**WEST SUSSEX COUNTY COUNCIL
STRATEGIC PLANNING CONSULTATION**

SUBJECT: AL/111/16/OUT -Outline application with some matters reserved for 57No. units with public open space & affordable housing. This application is a Departure from the Development Plan.

Land East of, Orchard Gardens, Aldingbourne, West Sussex

Drawing 5919/100 showing Right Turn Lane

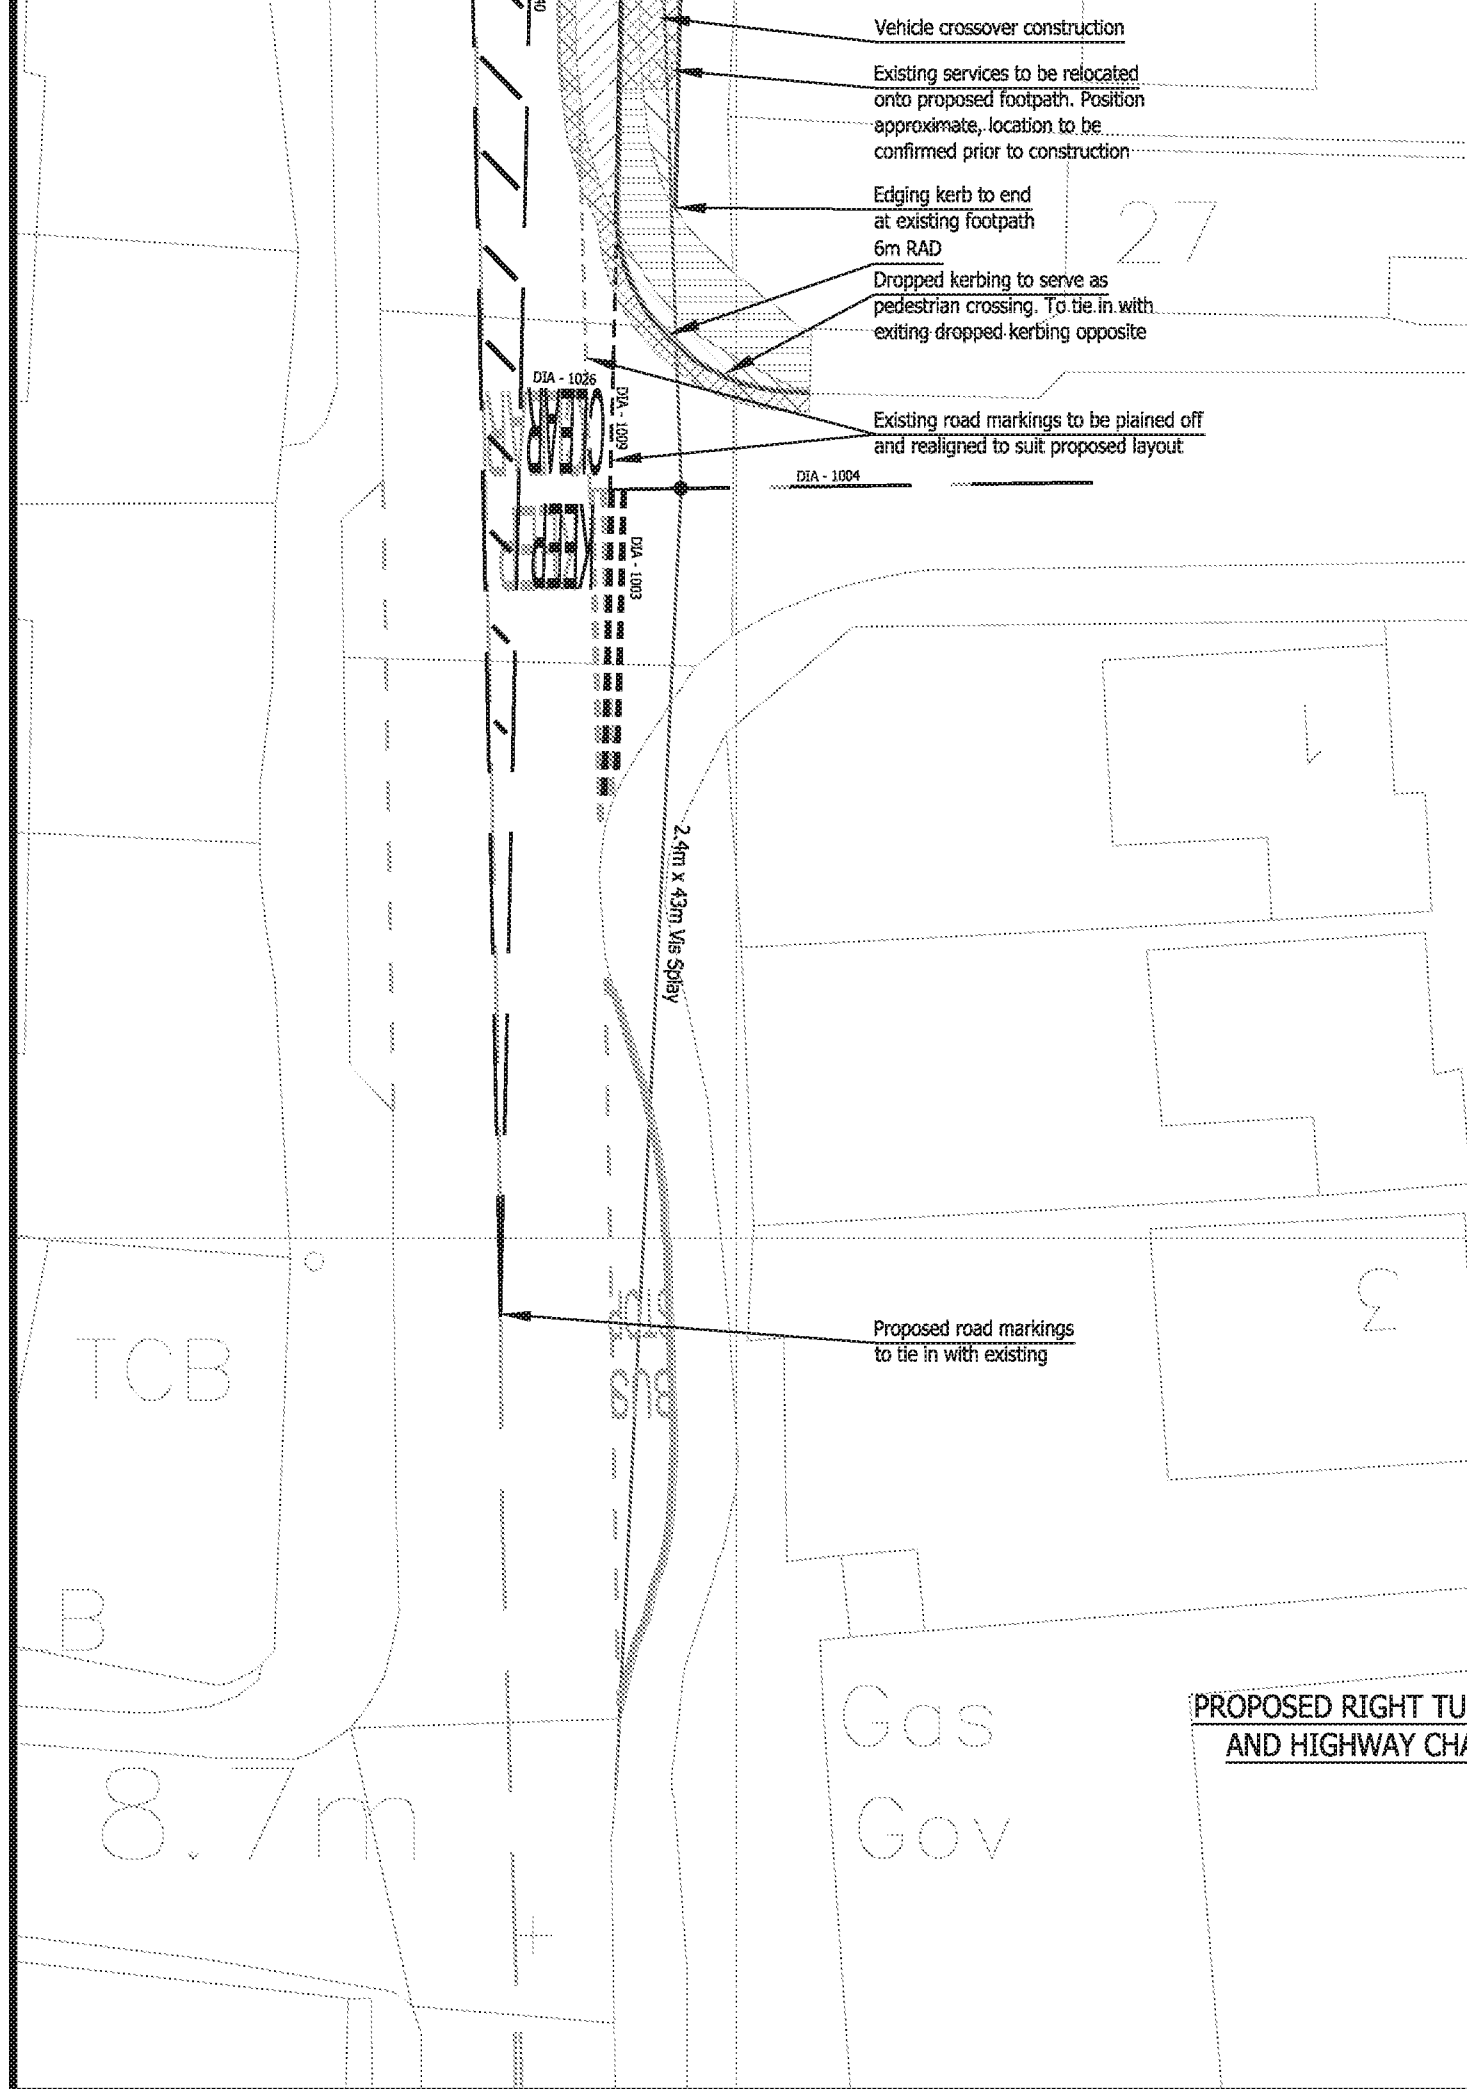
As part of the proposals reviewed within the TS the applicant is proposing a RTL in an attempt to alleviate queuing into the junction of Orchard Gardens. Having reviewed the RTL the LHA would draw the applicant's attention to a number of schemes approved as part of a 2013 in Hook Lane. This was a proposal for 79 dwellings and was approved under application number AL/39/13. This application proposed highway improvements to the A29, in summary these were:

'committed' status. In relation to the Hook Lane RTL improvement, given the proximity to the development site access, it will be necessary for the Applicant to consider how this may interact with the access proposals. Revised drawings including both improvements should be provided and, if necessary, access arrangements to be reconsidered to ensure compatibility.

In addition, a Design Audit of the RTL should be provided, setting out how the proposal accords with relevant Design Manual for Roads and Bridges parameters. Any departures, such as the provision of MfS visibility splays, should be applied for in accordance with GD01/08 utilising the Departure from Standards application process. Both an application form and guidance on the production of a Design Audit is attached to the covering email.

The proposed RSA identifies no problems with the proposed access and RTL arrangements. However, taking into account the points raised above regarding the Hook Lane application, the LHA would request that the RSA is revised and re-considered to incorporate the RTL proposed for Hook Lane application and any revisions to the access arrangements that may result.
